Our Ref: LU/205/26/NMA

**Section 96A of the Town & Country Planning Act 1990 (as amended)
Town and Country Planning (Development Management Procedure) (England) Order 2015
(as amended) - Article 10**

Non material amendment following the grant of LU/206/21/RES relating to relocation of northern footpath, changes to landscaping and boundary treatments.

Phase 5 Hampton Park Toddington Lane Littlehampton BN17 7PL

LA.PH5.5.
NMA_2

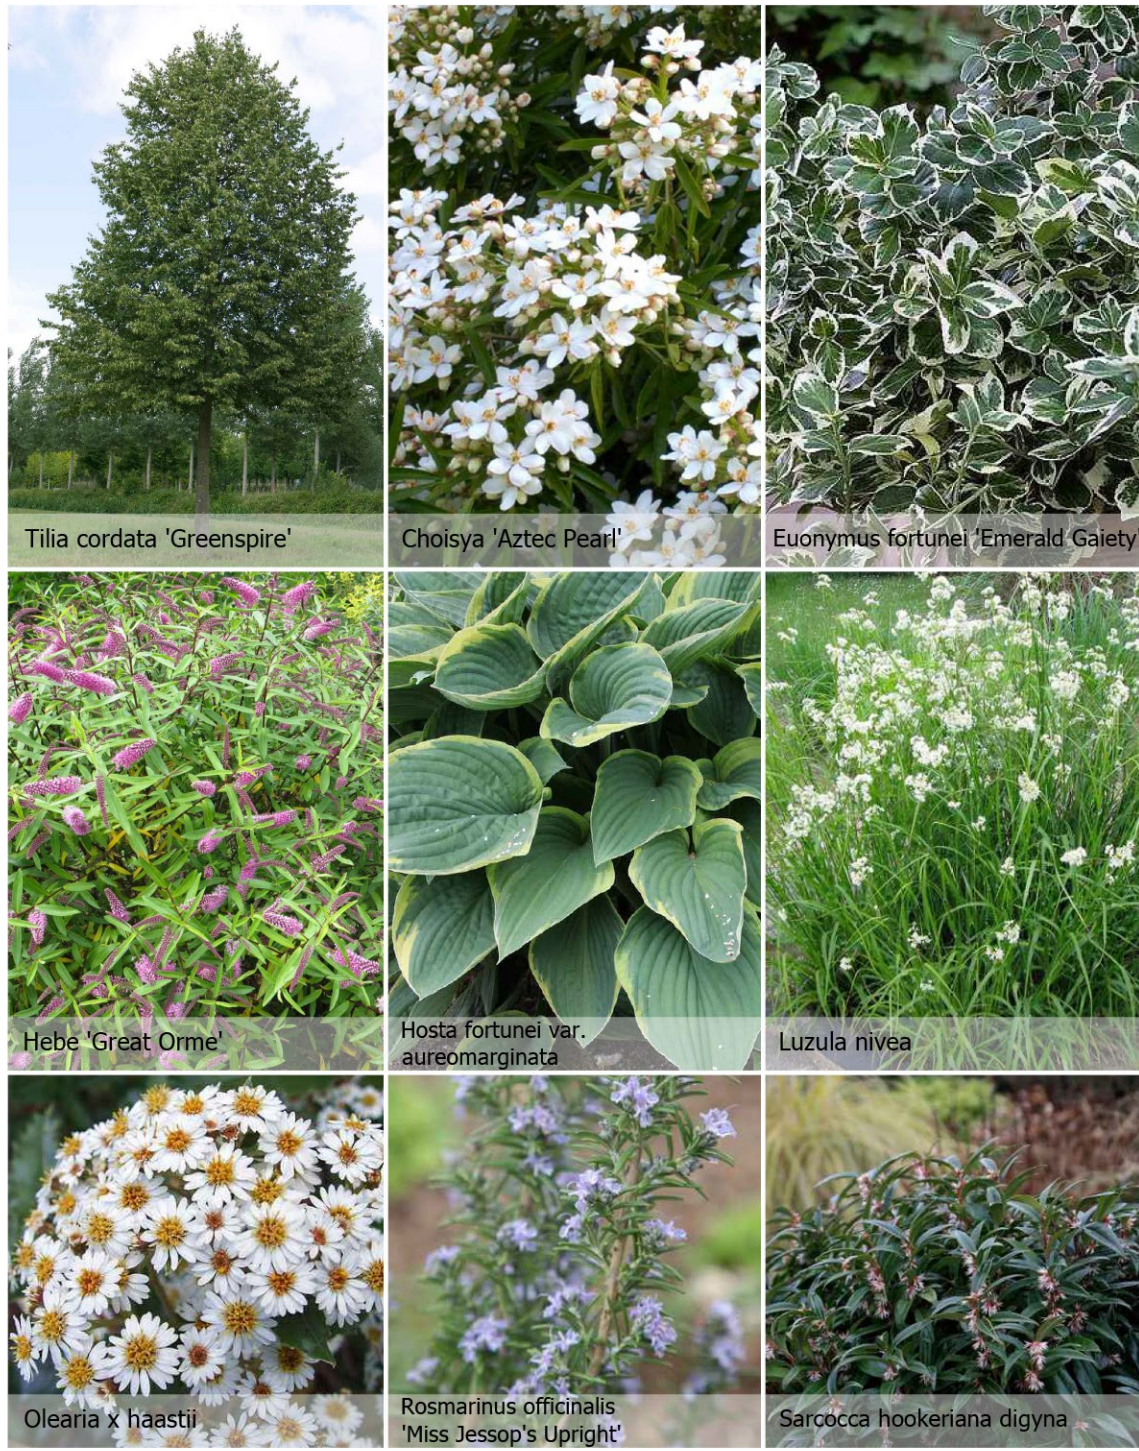
This application cannot be accepted as a Non-Material Amendment. The proposed revision to the red line boundary would materially alter the extent of the approved application site by incorporating land beyond that which formed part of the Reserved Matters (LU/206/21/RES). Additionally, in reviewing the proposed amendments against the existing approved plans under the RM, and the details approved for Condition 10 under LU/47/11/ (LU/135/24/DOC), there are found to be fundamental discrepancies between the drainage scheme that has been approved for Phase 5, and that which is proposed under this NMA (as shown in the Section 104 Agreement Plan 21044_100S104_O). The proposed changes are deemed to be material, and are considered inappropriate for approval under this form of application. This is due to the unknown implications arising from the relocation of the footpath and the changes to the drainage scheme, and whether this results in significant impact to the drainage infrastructure for Phase 5. These changes therefore require consultation with the ADC Drainage Engineer to determine whether the amended scheme is acceptable, and would allow the site to drain sustainably without increasing flood risk.

For these reasons, the proposed changes are considered material and require consultation. They therefore fall outside the scope of a Non-Material Amendment and must be refused.
